Application No: EP/26/22/HH
Site Address: 58 Sea Road East Preston BN16 1LP
Description of works: Erection of single storey side and rear extension and first floor side extension following the demolition of existing rear conservatory and first floor terrace.

Thank you for your internet representation made on 11th April 2022 which has been recorded as no objection with the comments as follows:

P002 **Proposed Block Plan**

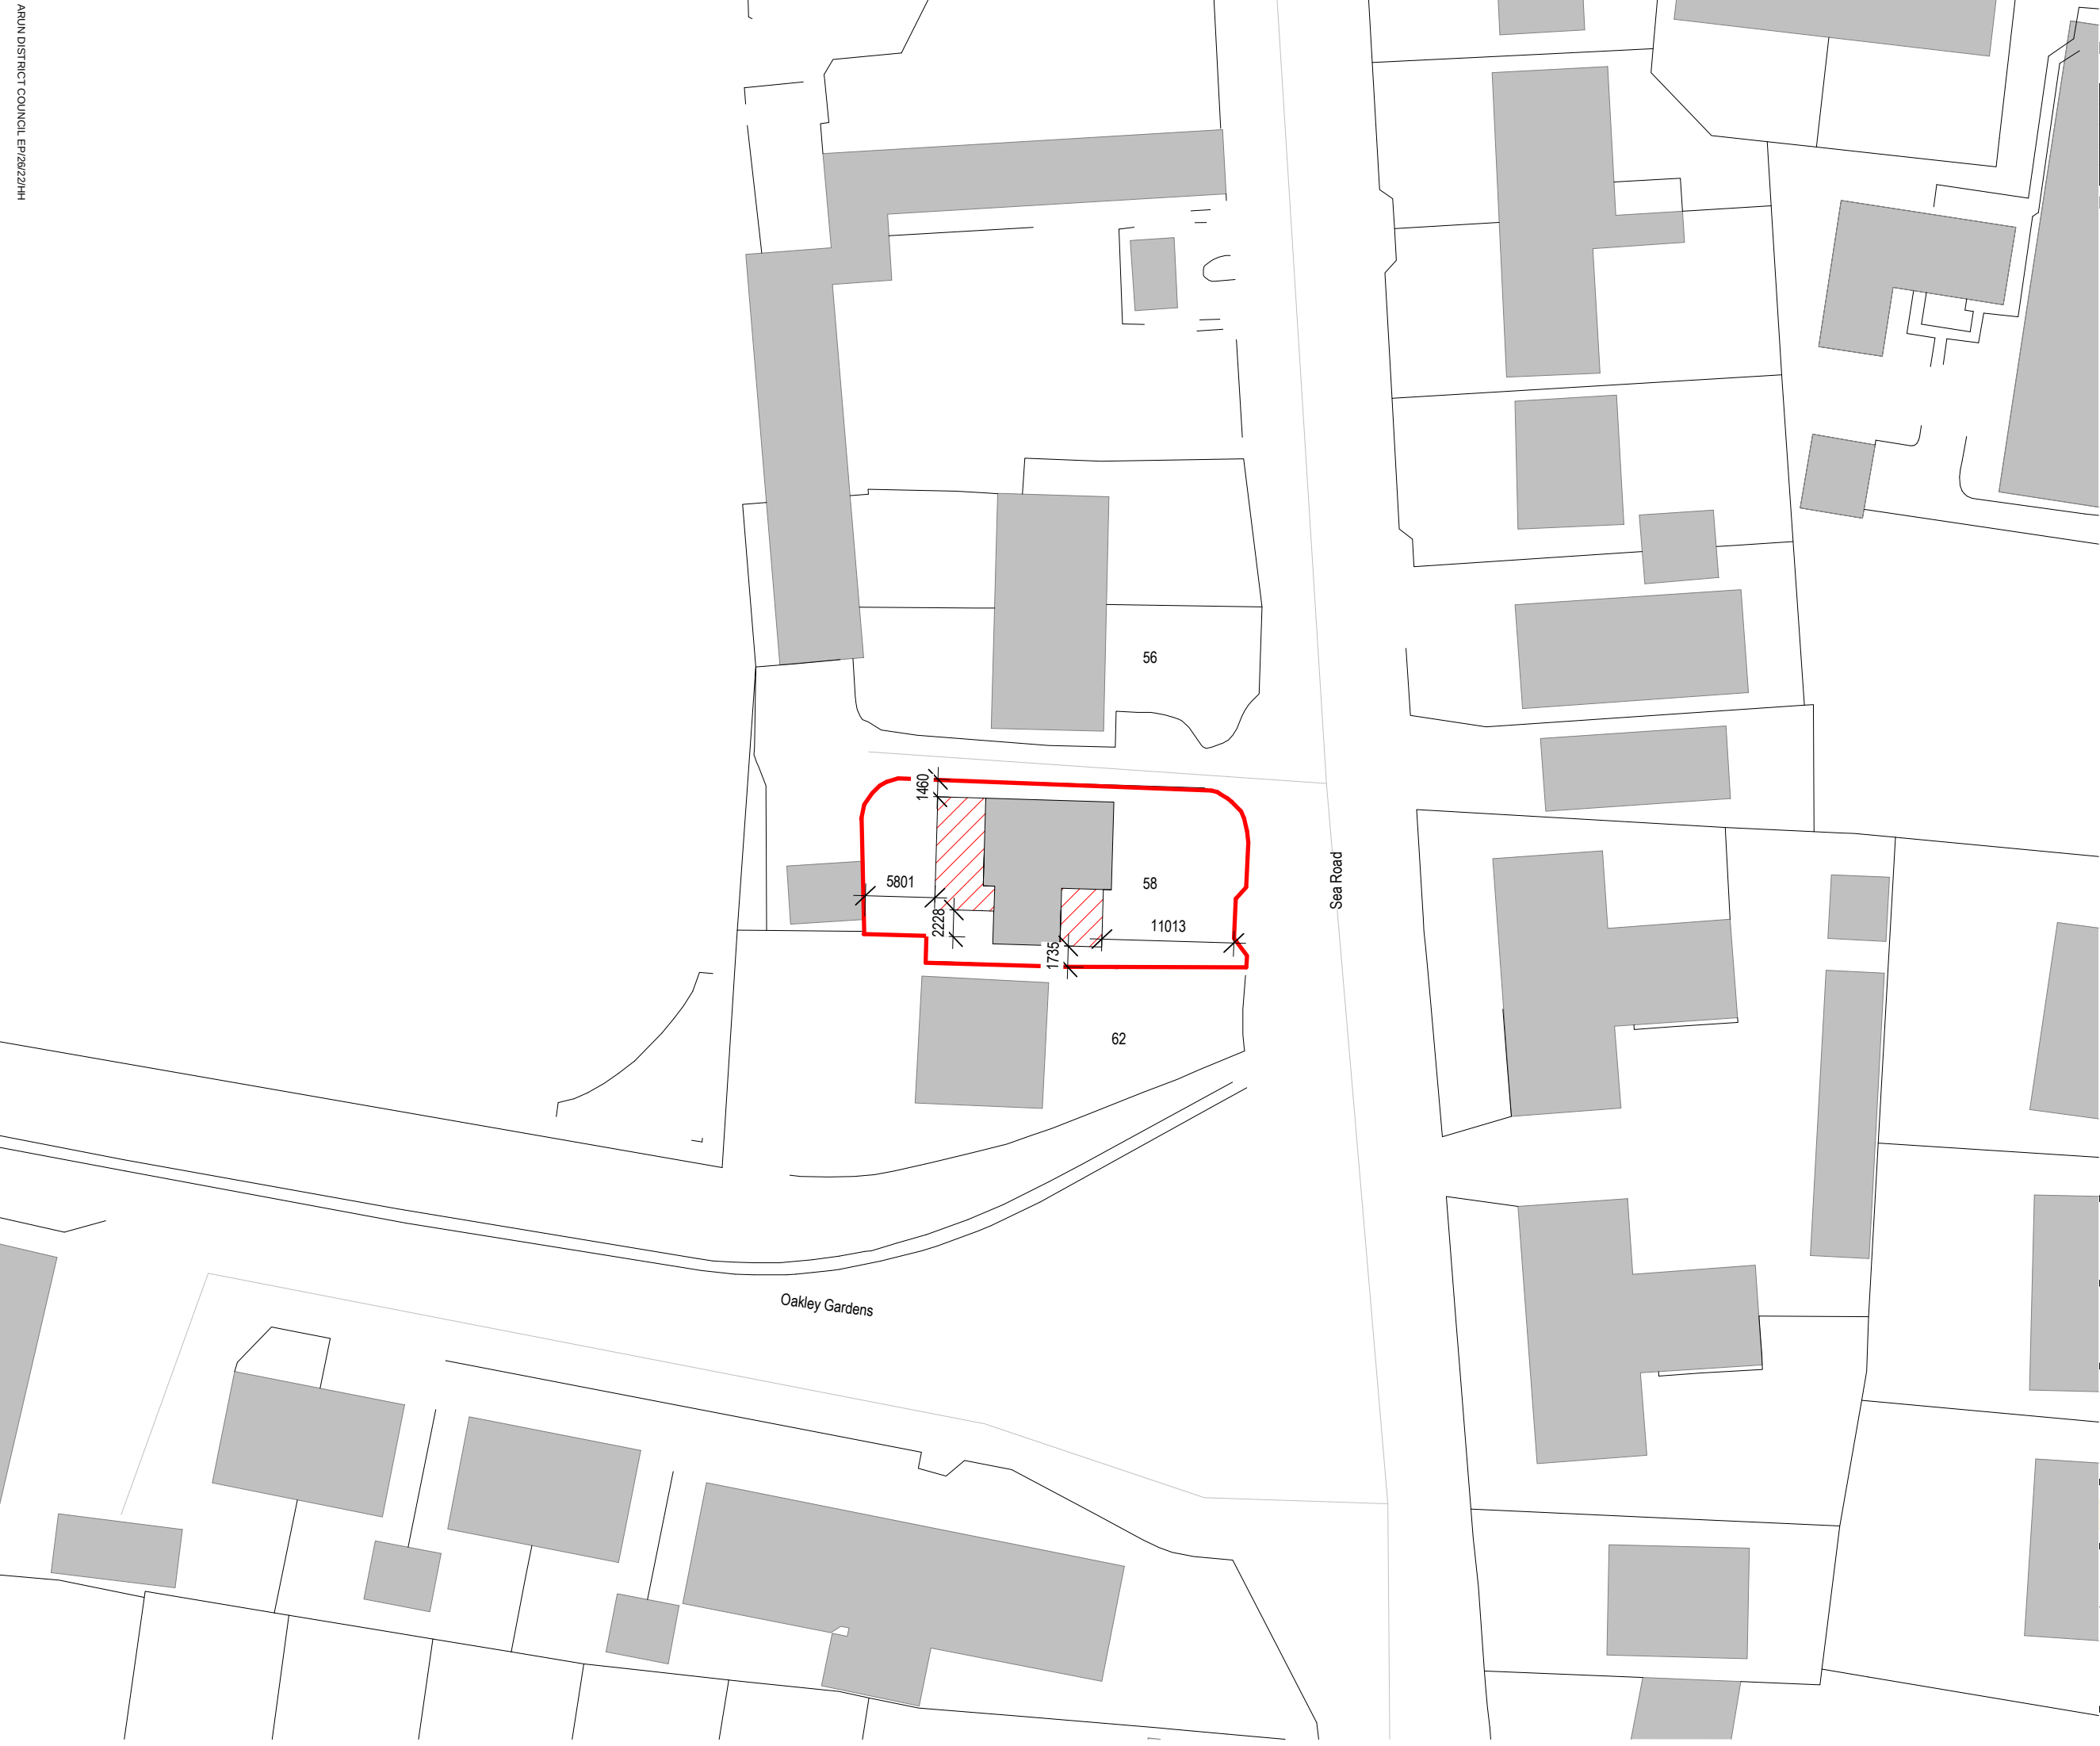
I write on behalf of the East Preston and Kingston Preservation Society, which has no objection to the proposed changes to the building. We have some concerns, however, about the fact that there seems to have been no consultation with the Conservation Officer or Drainage Engineer, nor a landscape plan, given the siting of this house next to a listed building and the 3D visualisation not showing any vegetation apart from a tiny amount at the front boundary, with the whole front area paved. Is this material to be impermeable? While at present there is hard standing over most of the front garden, there are shrubs at the sides, and screening at the front. The Application states that they would not need to be removed or pruned, contrary to the illustration. The Society would be reassured were there to be some substantial planting plan to screen the building and for the paving material to be permeable or at least provision made for sustainable drainage.
